LSC Responses to PCD CD Redline Comments

WALKER RD. SIGNING AND STRIPING PLAN Walker Rd./Jane Lundeen/Pinehurst Signing and Striping Plan

WALKER RD. (EAST) SIGNING AND STRIPING PLAN Hwy 105/Walker Rd./Jane Lundeen/Pinehurst Signing and Striping Plan

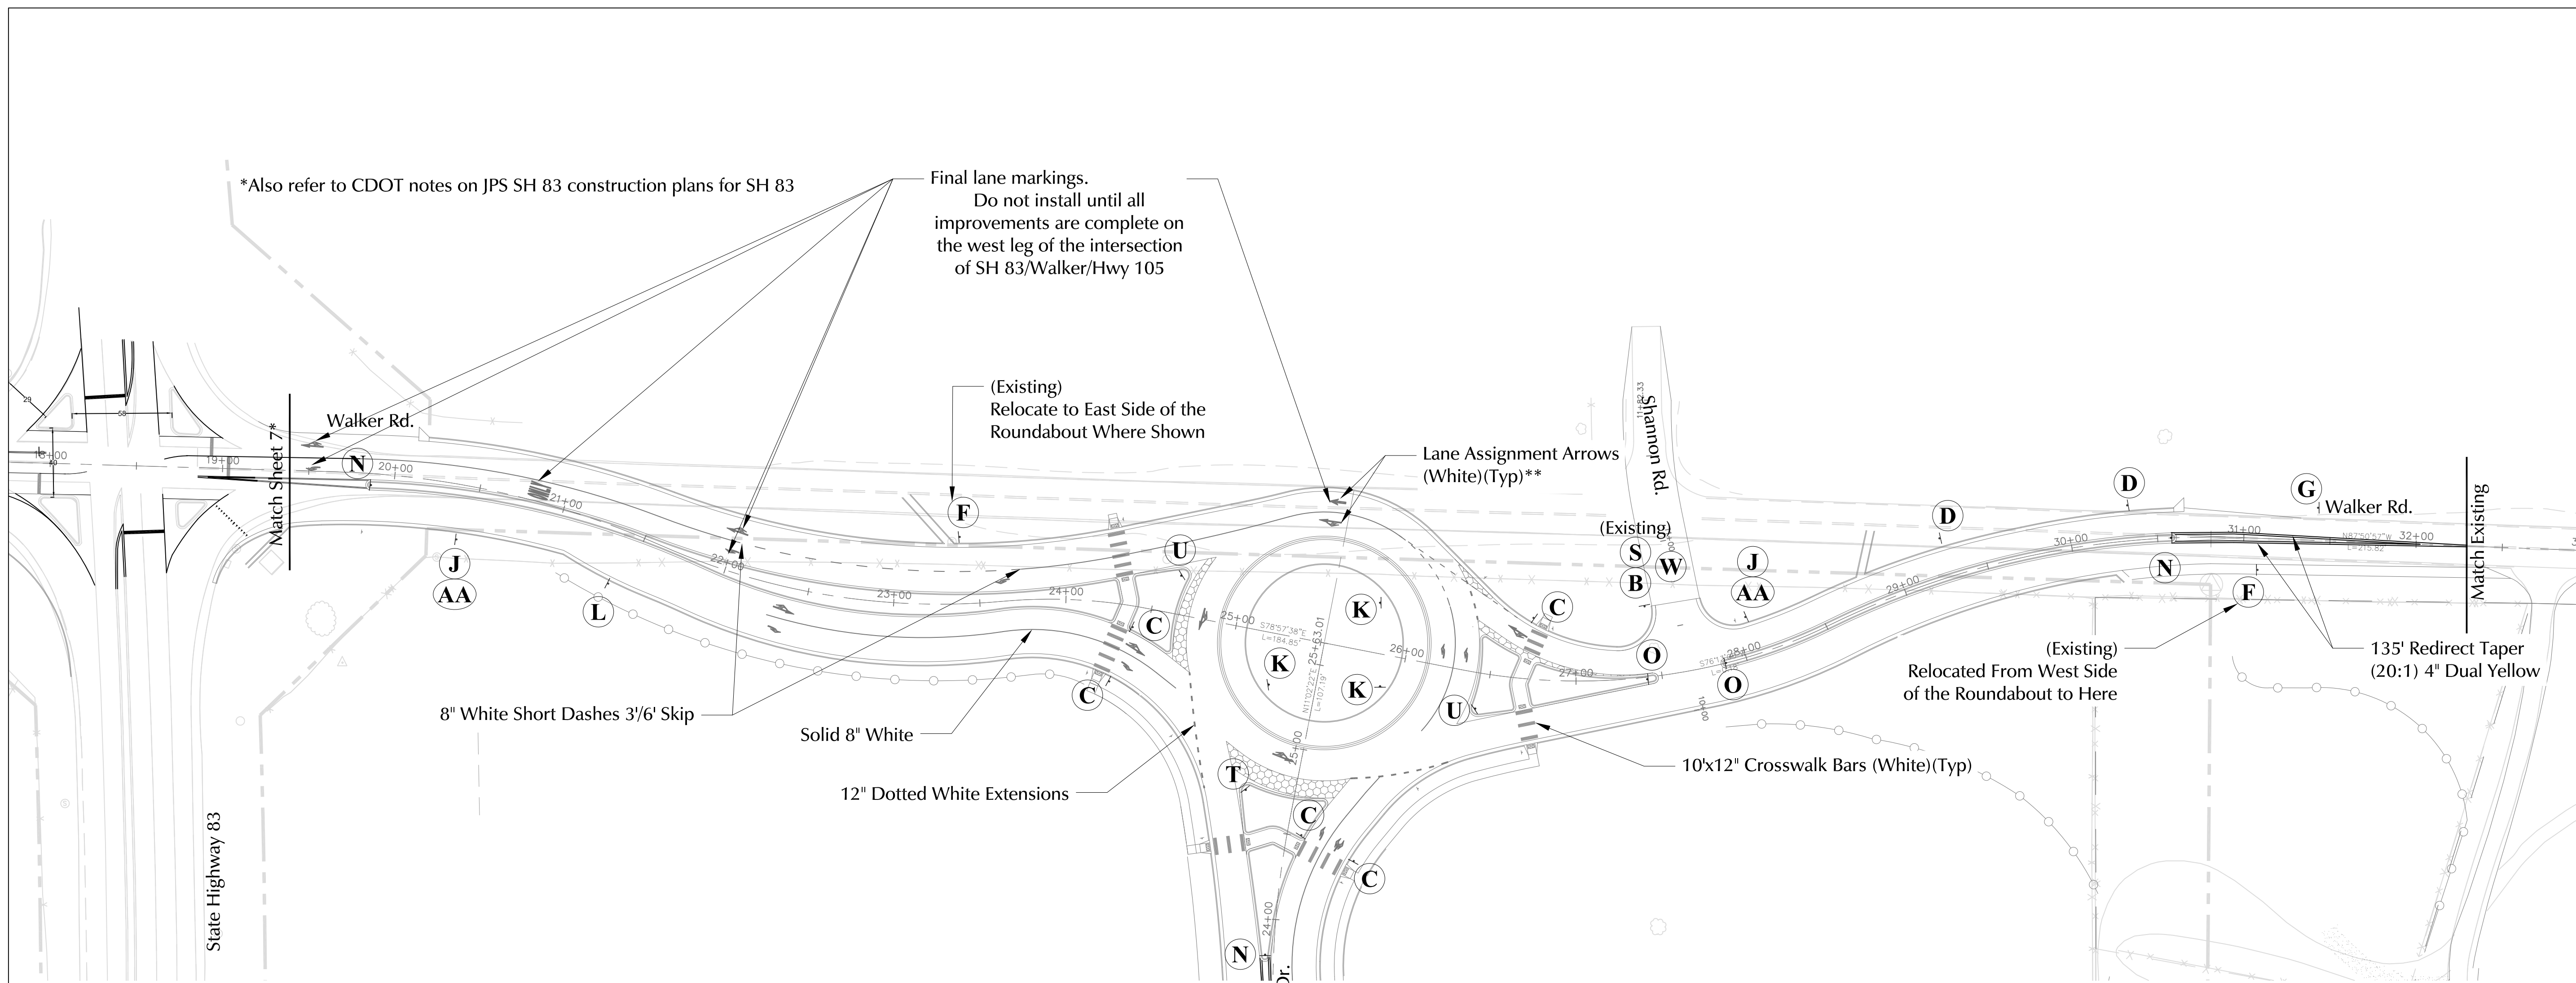
Is this arrow needed?

Provide R6-4b in the central island opposite each entrance. Move "C" yield signs to roundabout side of ped ramps (where dots are shown)"D" signs can be on same post as street names at roundabout exits. See McLaughlin plans for example signage.

Place yield bars further back (at curb or 21 ft from edge of crosswalks)

Delete placard, add advance street name.

Provide slanted arrows up and to the right where applicable

Use fluorescent with "school" placards

delete - covered by yield sign placement

LSC Response: This is recommended along with the "ONLY" because this lane will essentially be a left "drop" lane. This was shifted west slightly.

Author: jchodsdon Subject: Sticky Note Date: 8/19/2020 13:22:46
LSC Response: Revised as requested.

Author: jchodsdon Subject: Sticky Note Date: 8/19/2020 13:24:29
LSC Response: Revised as requested.

Author: jchodsdon Subject: Sticky Note Date: 8/19/2020 13:21:24
LSC Response: Deleted as requested. Added street name sign plates AA, BB and CC.

Author: jchodsdon Subject: Sticky Note Date: 8/19/2020 13:21:45
LSC Response: Revised as requested.

Author: jchodsdon Subject: Sticky Note Date: 8/19/2020 13:20:16
LSC Response: Revised as requested.

Author: jchodsdon Subject: Sticky Note Date: 8/19/2020 13:17:10
LSC Response: Deleted as requested.

SHT NO. **8**
OF 10

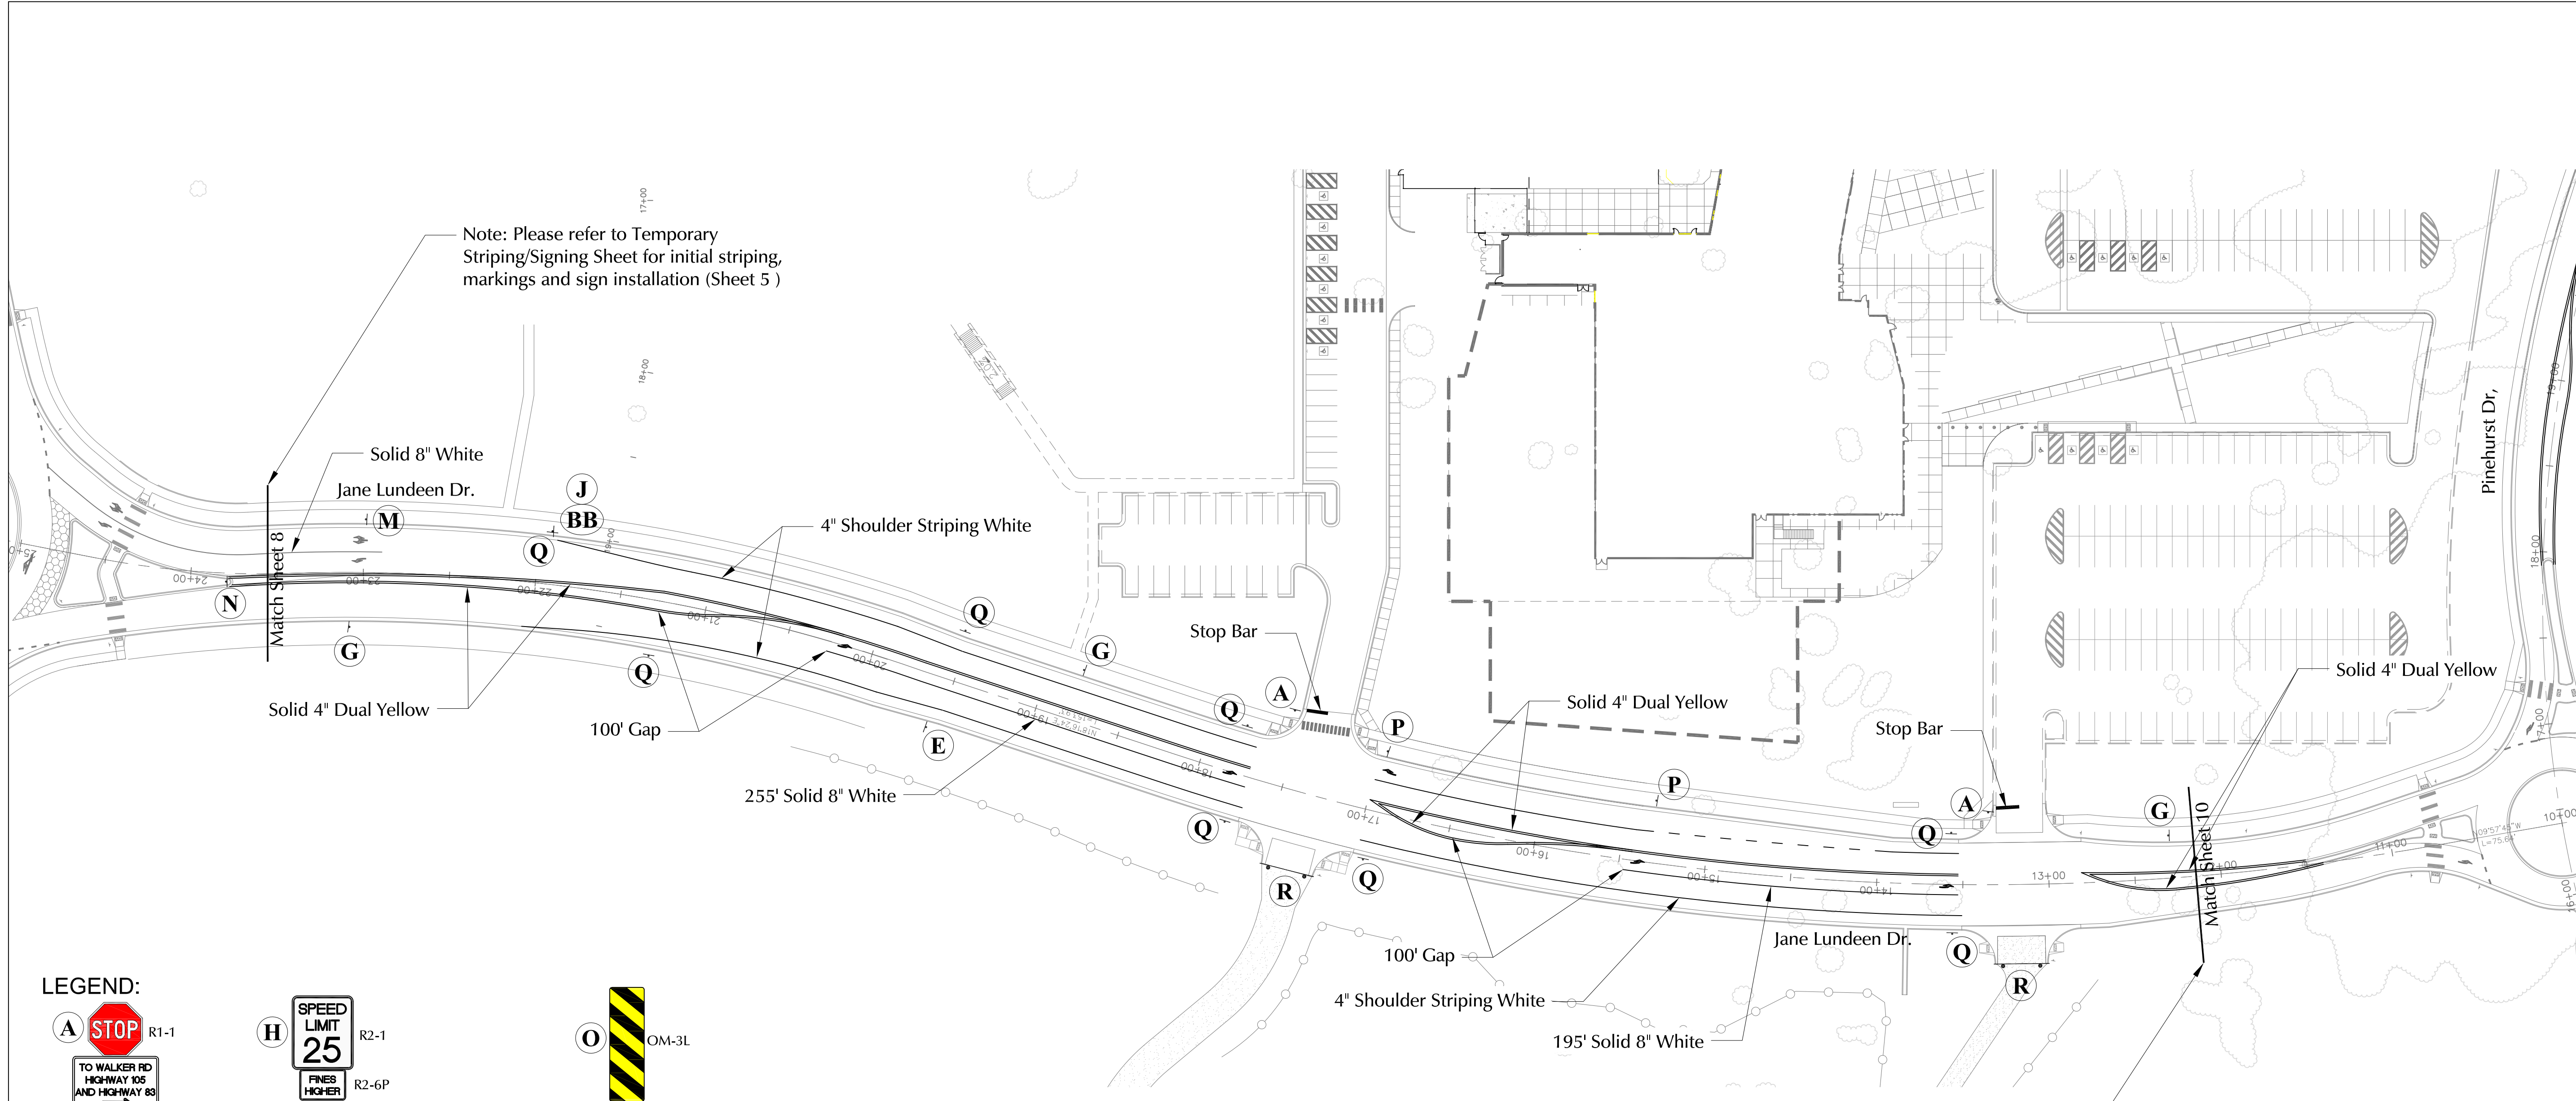
Use fluorescent with "school" placards

delete - covered by yield sign placement

Author: jchodsdon Subject: Sticky Note Date: 8/19/2020 13:26:31
LSC Response: Revised as requested.

Author: jchodsdon Subject: Sticky Note Date: 8/19/2020 13:25:05
LSC Response: Deleted as requested.

SHT NO. : 9
OF 10

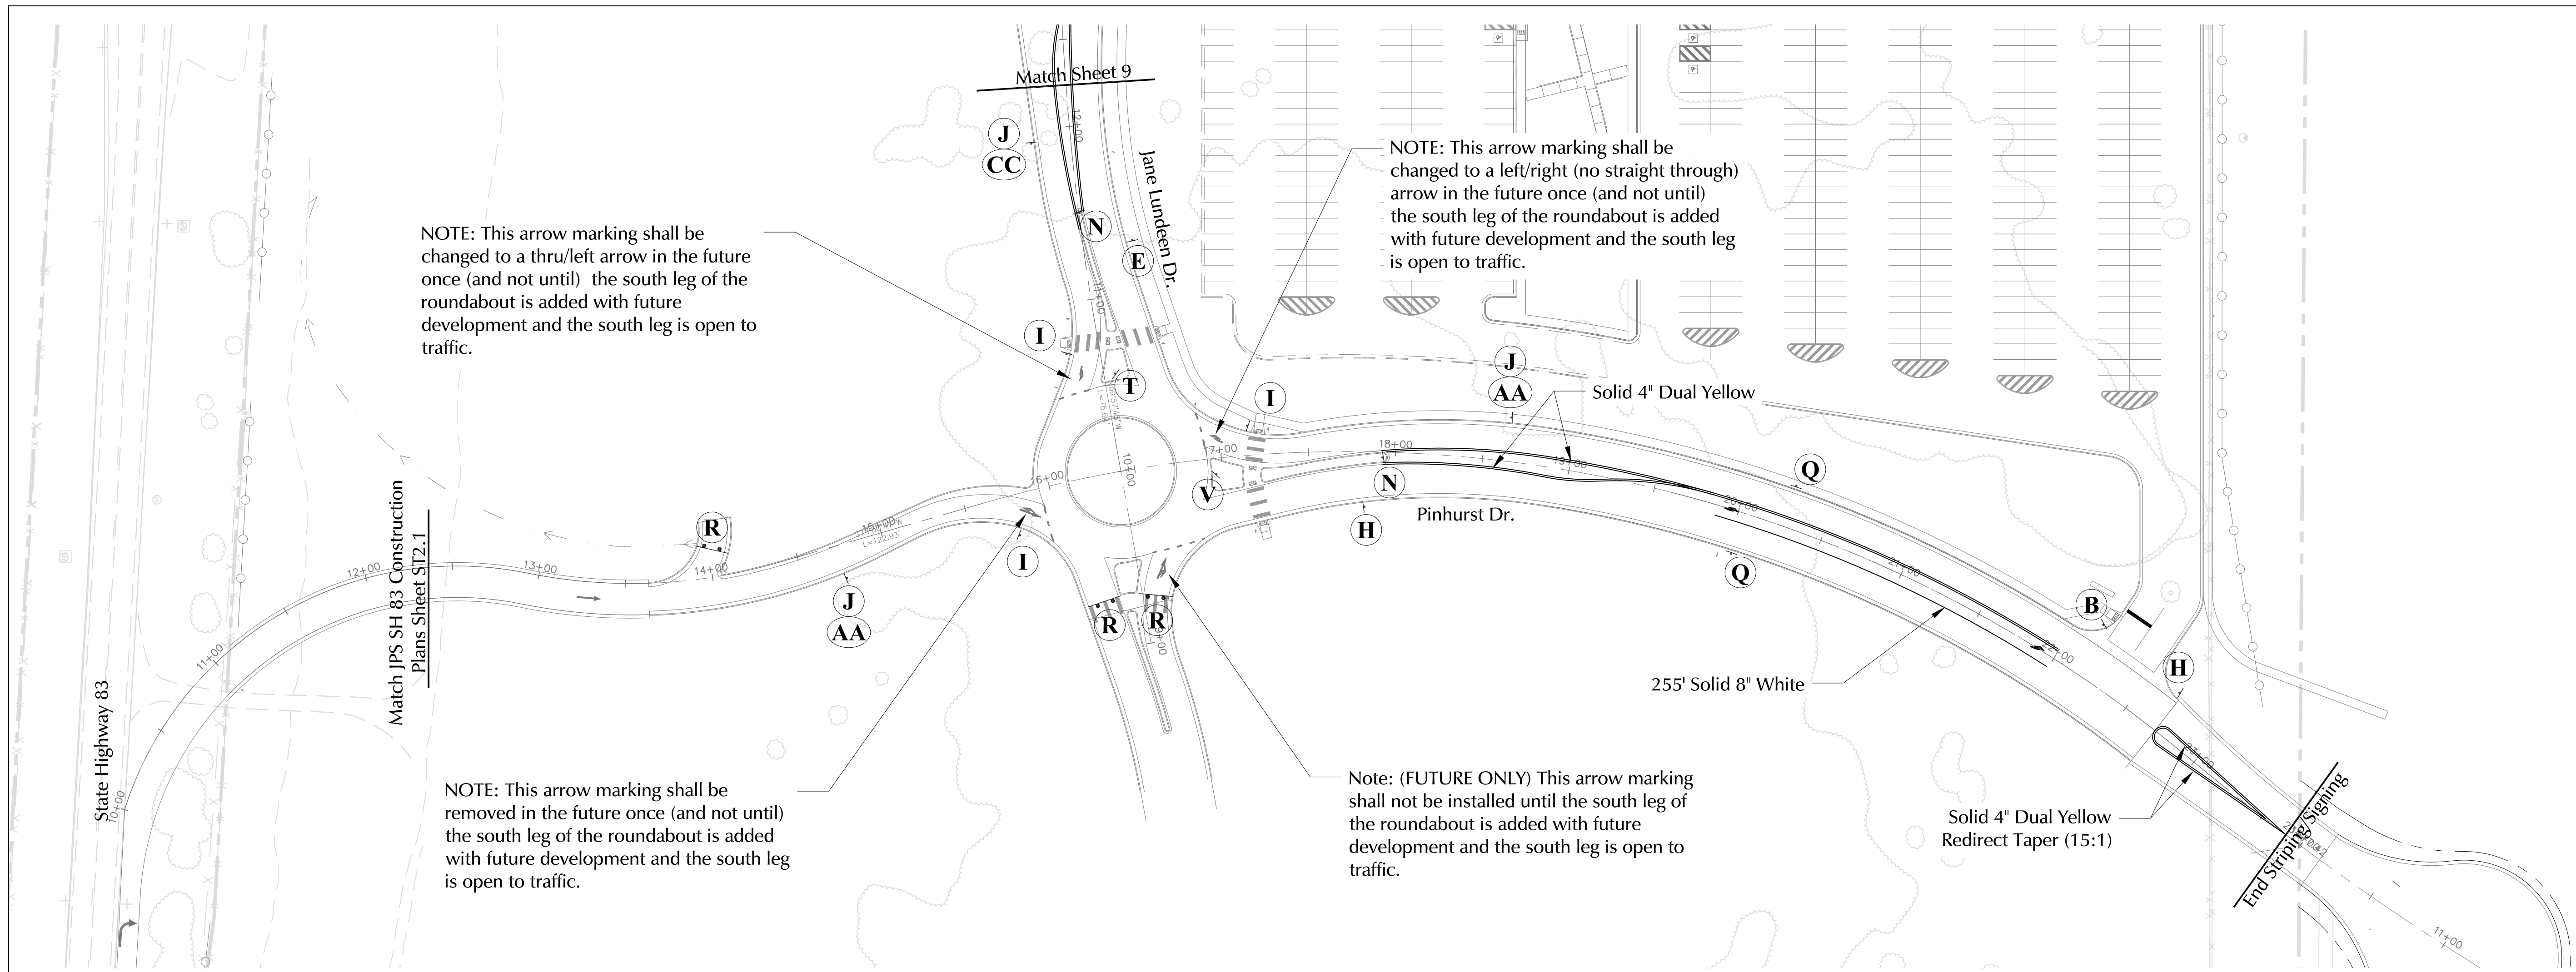
OM-3R? In the interim with barricaded south leg?			
	Author: jchodsdon	Subject: Sticky Note	Date: 8/19/2020 13:41:04	
	Follow up - NOT included as it would conflict with Autoturn vehicle turning paths.			
	Number: 13	Author: dsdrice	Subject: Image	Date: 8/12/2020 16:30:07
	Number: 14	Author: dsdrice	Subject: Callout	Date: 8/12/2020 13:38:36
	D			
	Author: jchodsdon	Subject: Sticky Note	Date: 8/19/2020 13:43:14	
	D signs removed on the south leg, and on the future departure leg side of the splitter island; NOTE: The street name signs and some ped. crossing signs have been moved to alternate locations on the revised plan set so as to not conflict with the autoturn vehicle turning paths from the roundabout design report.			
	Number: 15	Author: dsdrice	Subject: Text Box	Date: 8/12/2020 16:35:04
	Move "C" yield signs to roundabout side of ped ramps (where dots are shown)			
	Author: jchodsdon	Subject: Sticky Note	Date: 8/19/2020 13:36:57

speed limit sign?

Label taper/redirect ratios

Add "Fines Higher" placard

Delete placard, add advance street name.

add "no left turn" when all roads are open

R2-125 MPH?

Show P & R on this sheet

Use fluorescent with "school" placards

delete - covered by yield sign placement

LSC Response: We shifted the advance ped warning sign to the west on the approach to the roundabout

Instead of the 20 mph school speed zone sign depicted in these comments, the 25 mph sign w/ Fines Higher is shown in this location upstream of the school access.

A 20 mph speed limit sign is shown on the JPS signing & striping plans for SH 83. John's plans. The match line note includes a reference to those plans.

LSC Response: Added as requested.

LSC Response: Added as requested.

LSC Response: Deleted as requested. Added street name sign plates AA,BB and CC.

LSC Response: This has been added.

LSC Response: Added as requested, but placed upstream of the school access (westbound direction).

LSC Response: Added as requested. NOTE: The street name signs and some ped. crossing signs have been moved to alternate locations on the revised plan set so as to not conflict with the autoturn vehicle turning paths from the roundabout design report.

LSC Response: Revised as requested.

LSC Response: Deleted as requested.
